PLAN-010212

13/07/2015

Proposal: Single storey pitched roof rear extension.
Site: 6 Trundle View Close, Barnham, PO22 0JZ.
EG/40/15/HH

Block Plan 1:500

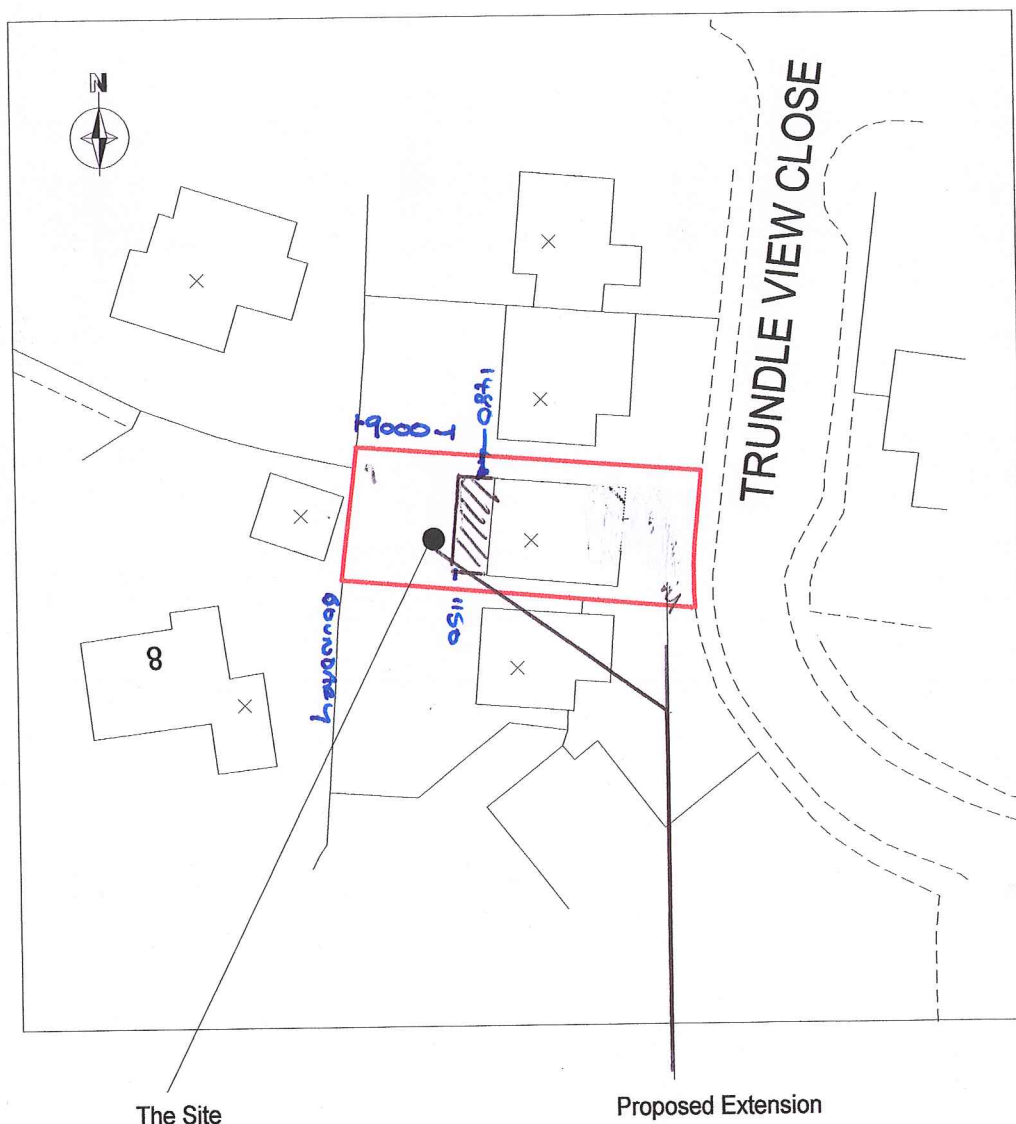
The attached plan shows that the proposed development lies close to an existing public foul and surface water sewers. An investigation of the sewer is required to ascertain its condition, the number of properties served, and potential means of access, before any decision can be made as to whether it would be acceptable for the proposed development close to the sewer. Part H of the Building Regulations dictates that the matter is determined by the sewerage undertaker – in this case Southern Water.

The applicant is advised to discuss the matter further with Southern Water, Sparrowgrove House, Sparrowgrove, Otterbourne, Hampshire SO21 2SW (Tel: 0330 303 0119) or www.southernwater.co.uk.

Southern Water requires a formal application for a new connection to the public foul and surface water sewer to be made by the applicant or developer.
